Dear Andrew,

Having reviewed this application with a colleague we can confirm that we do not recommend discharge of conditions 8 and 9 at this time. We have the following comments which require addressing:

Technical Specification

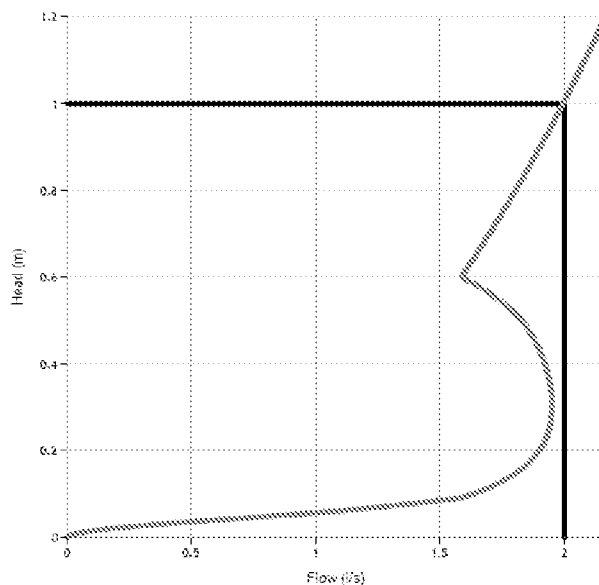
7. The layout states the hydrobrake will have a design head of 0.5m, this is inconsistent with the calculations and construction details. Please correct.

CLIENT	TL Homes		
PROJECT	Old Blacksmiths Yard Water Lane Angmering		
TITLE	Proposed Drainage and Levels Layout		
DRAWN	DATE	PROJECT NO.	22346
M Pacifico	July 2020		
ENGINEER	CHECKED	DWG. NO.	
S Doughty		REV.	
SCALE	1:100 @ A1

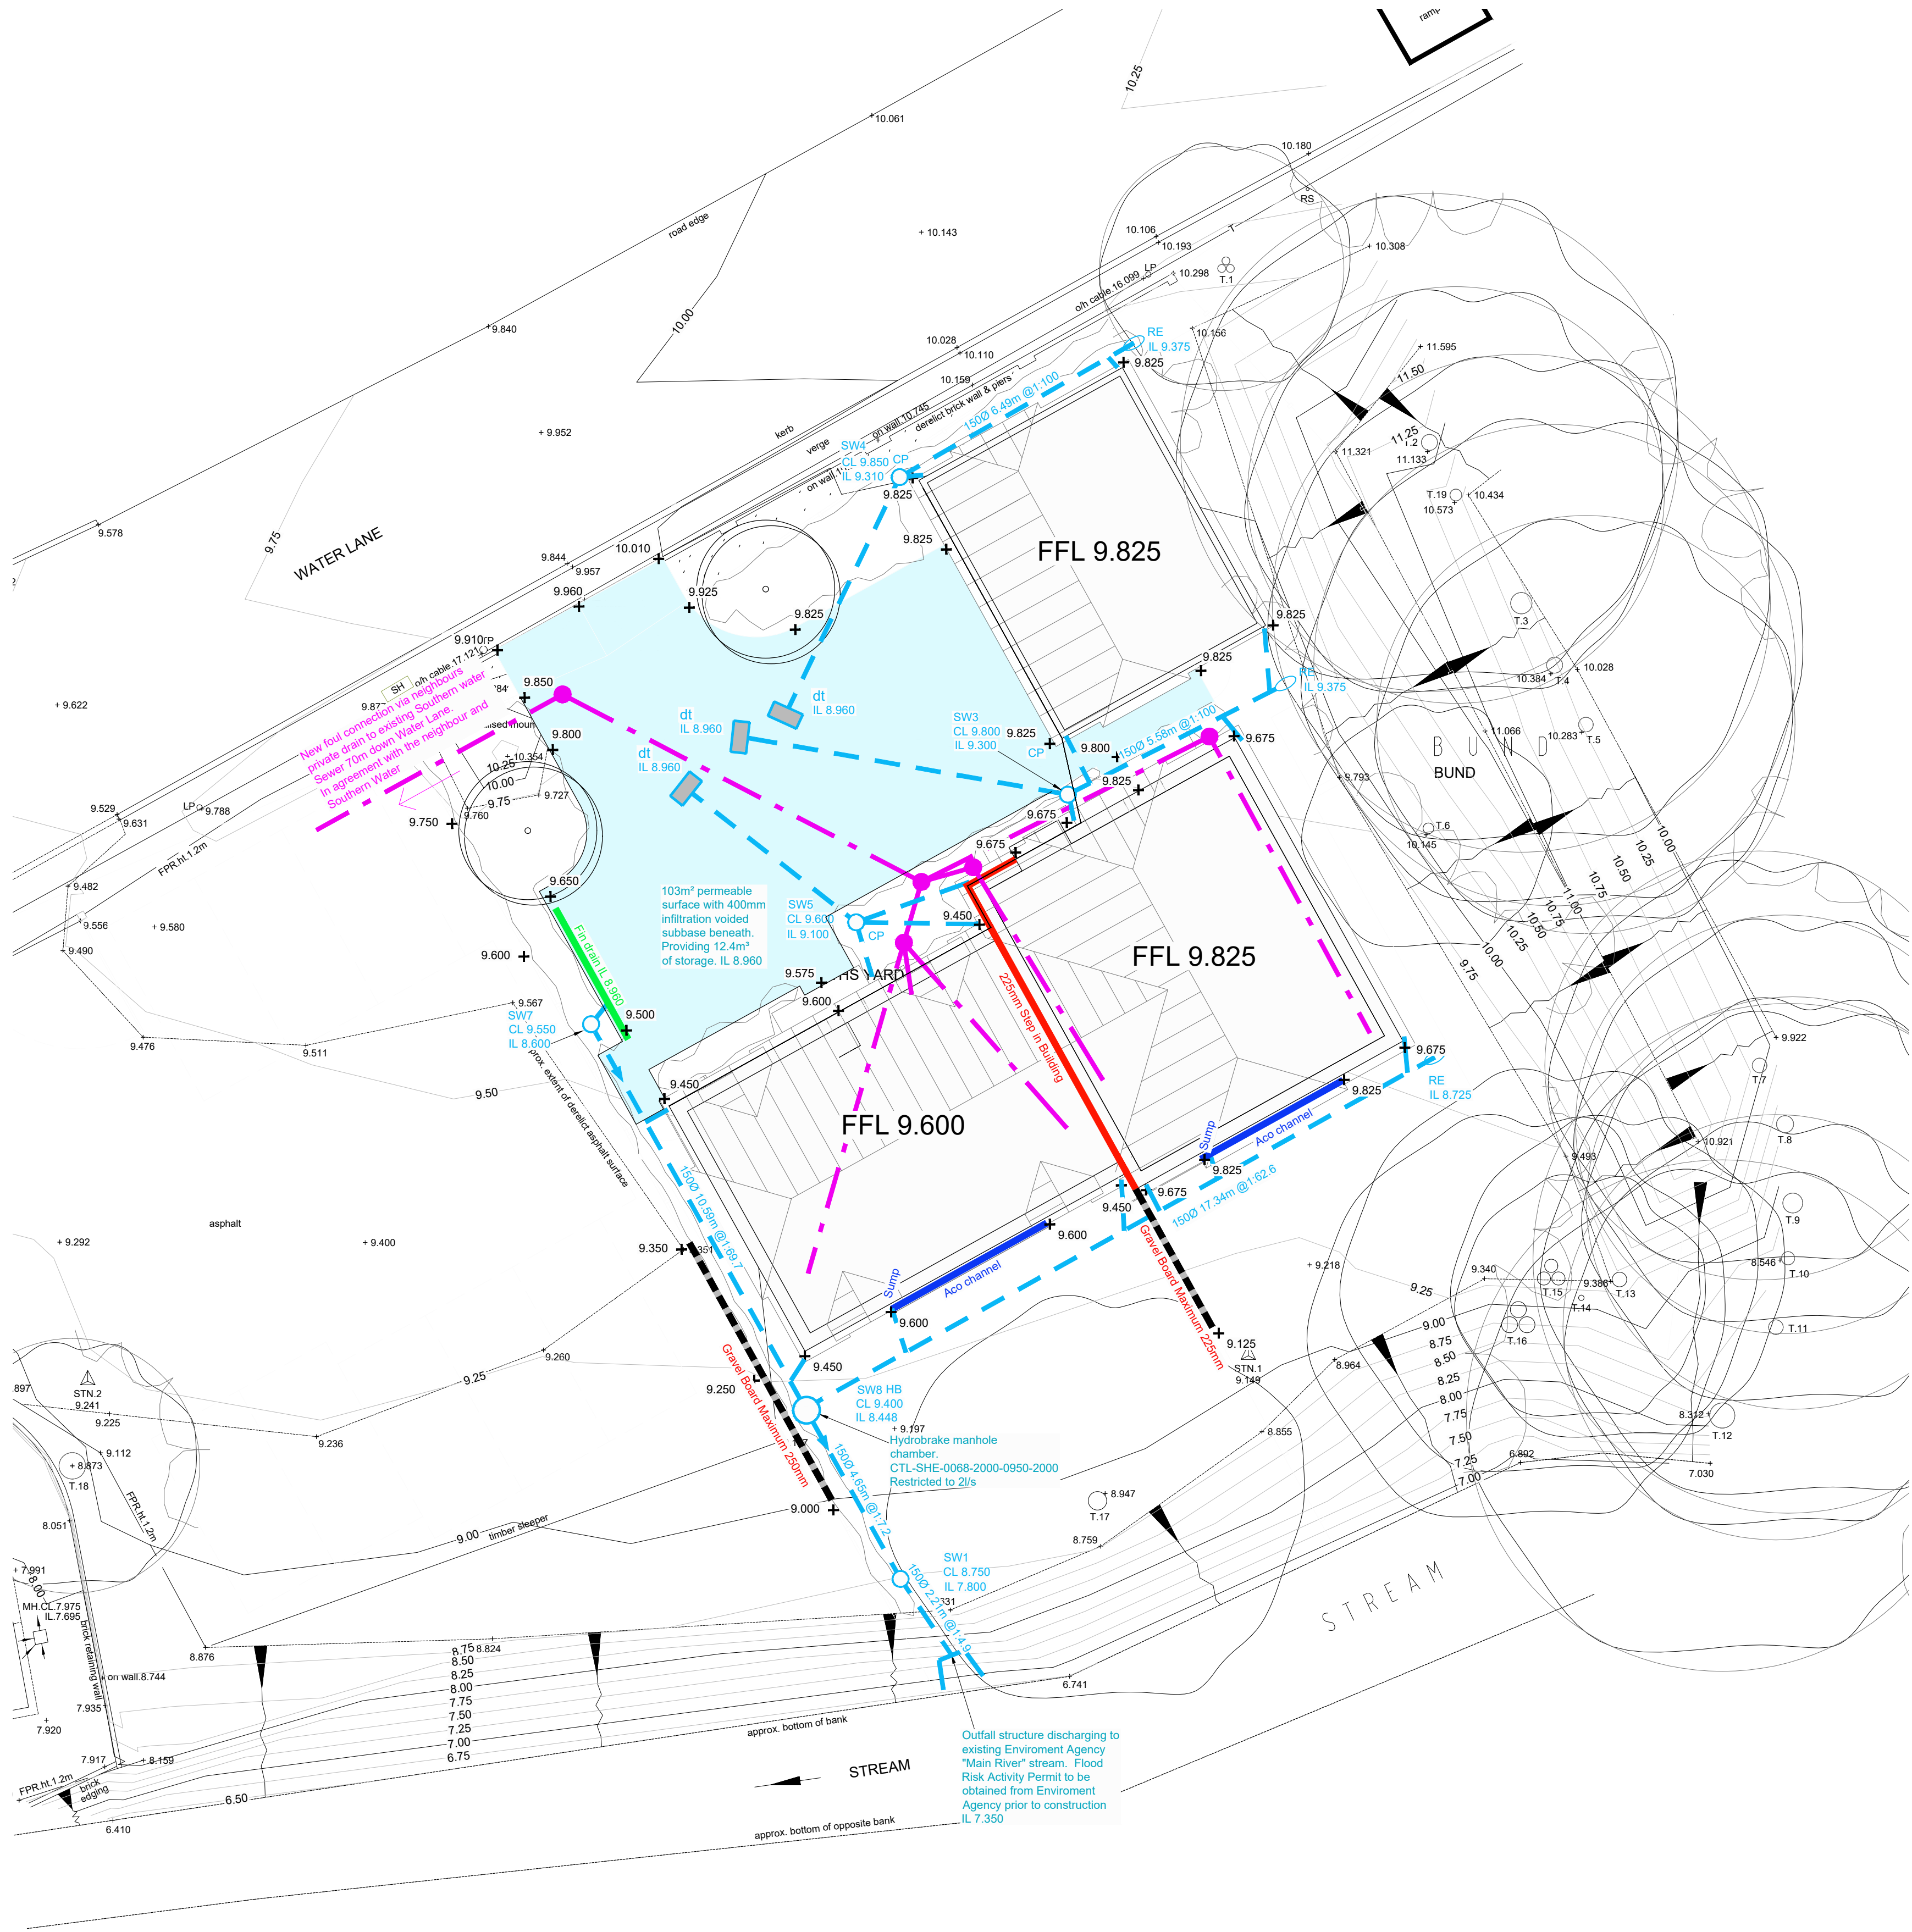
1. Please model a surcharged outfall with water levels equal to top of bank level adjacent to the outfall.
2. Please ensure that all modelled details correspond with those on plan, for example currently there are discrepancies between invert levels modelled and those shown on plan.

3. The amended drainage strategy states that the sub-base will be left unlined to allow for infiltration when possible. If the sub-base is to be unlined diffuser units must be located 5m away from proposed buildings.

4. The drainage strategy layout is cramped and not clear. Please provide a plan that is to scale and includes the following additional features; a) pipe materials and dimensions for all pipes b) invert levels of diffuser blocks and fil drain c) cover levels and cover types of all inspection chambers/manholes d) finish levels of permeable paving (we note that two ground levels are stated, please make it clear if these are proposed ground levels and include a further level near the garage)

5. Please provide silt traps upstream of all connections into the permeable paving.
6. We note that a Fildrain is proposed to collect water from the permeable paving sub-base and would ask whether collection via a diffuser block may provide a better means to collect water. This is not a point that would warrant us refusing discharge of conditions but is worth considering from a construction and maintenance perspective. We will however need invert levels of the foul drain to ensure no clash between the fildrain and sewer.

PERMEABLE BLOCK PAVING DRIVE CONSTRUCTION
VOIDED SUBBASE TANKED SYSTEM
(Scale 1:20)

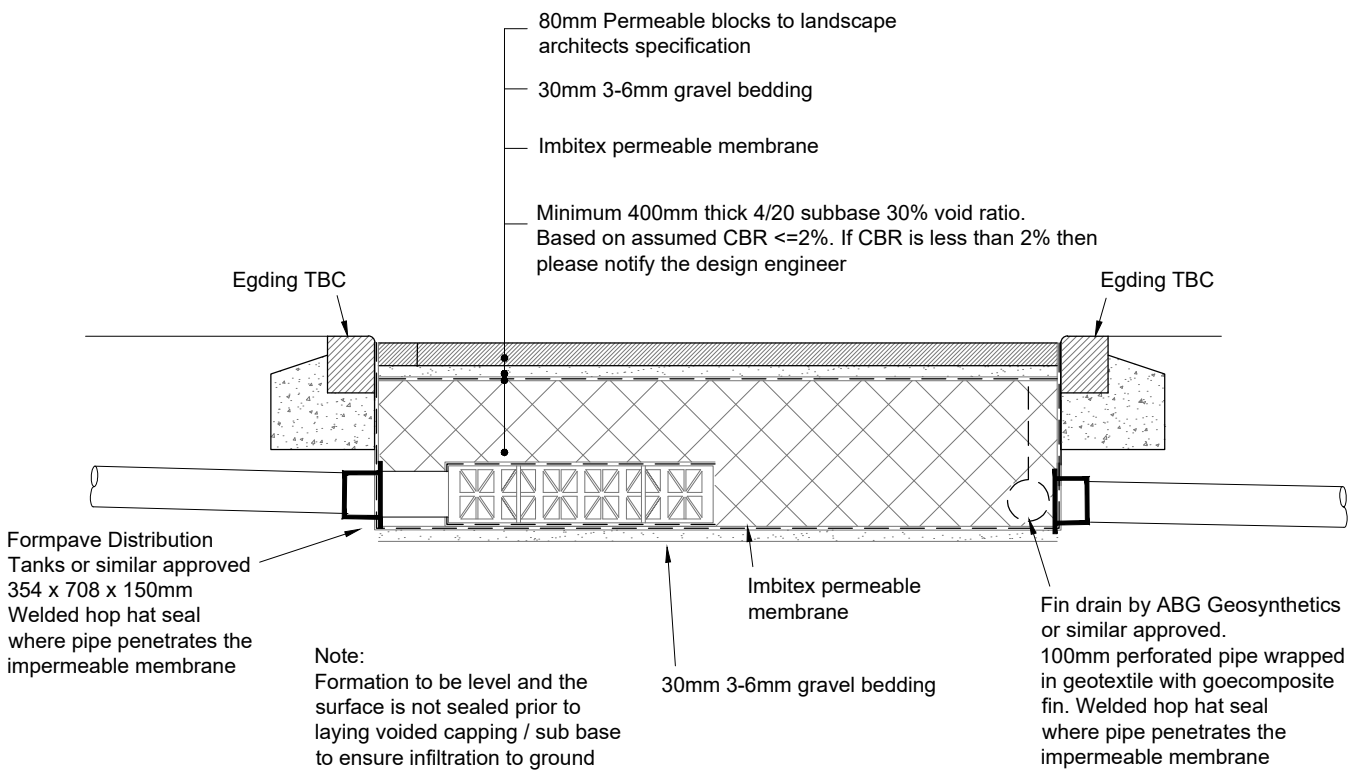
10. Please provide construction detail drawings of permeable paving, aco channel, manholes and catchpits. The permeable paving detail currently provided is not site specific and lacks material specification detail.

MANHOLE SW11 - HYDROBRAKE
(Scale 1:20)

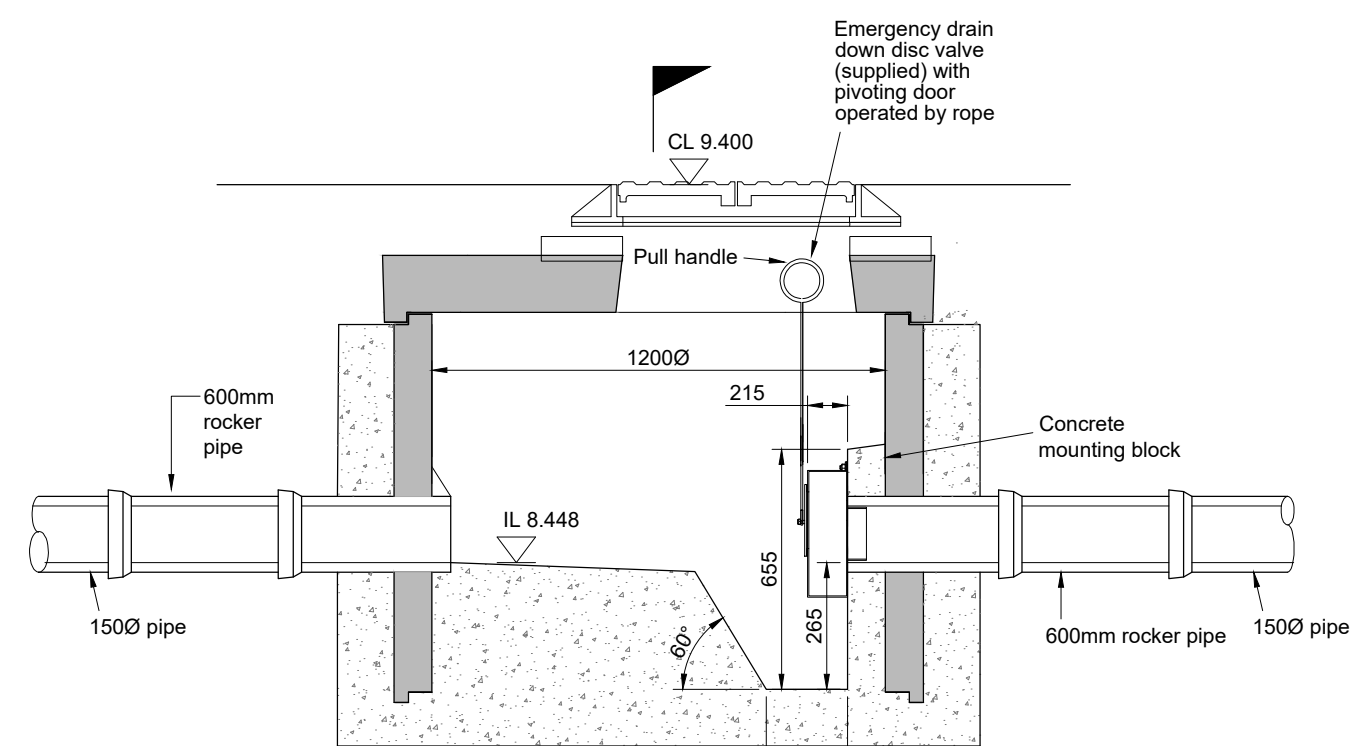
8. The hydrobrake construction detail needs to be site specific, i.e. include invert levels and cover levels. Step rungs should also be provided.
9. Please provide pipe bed and surround details that are consistent with approved document H.
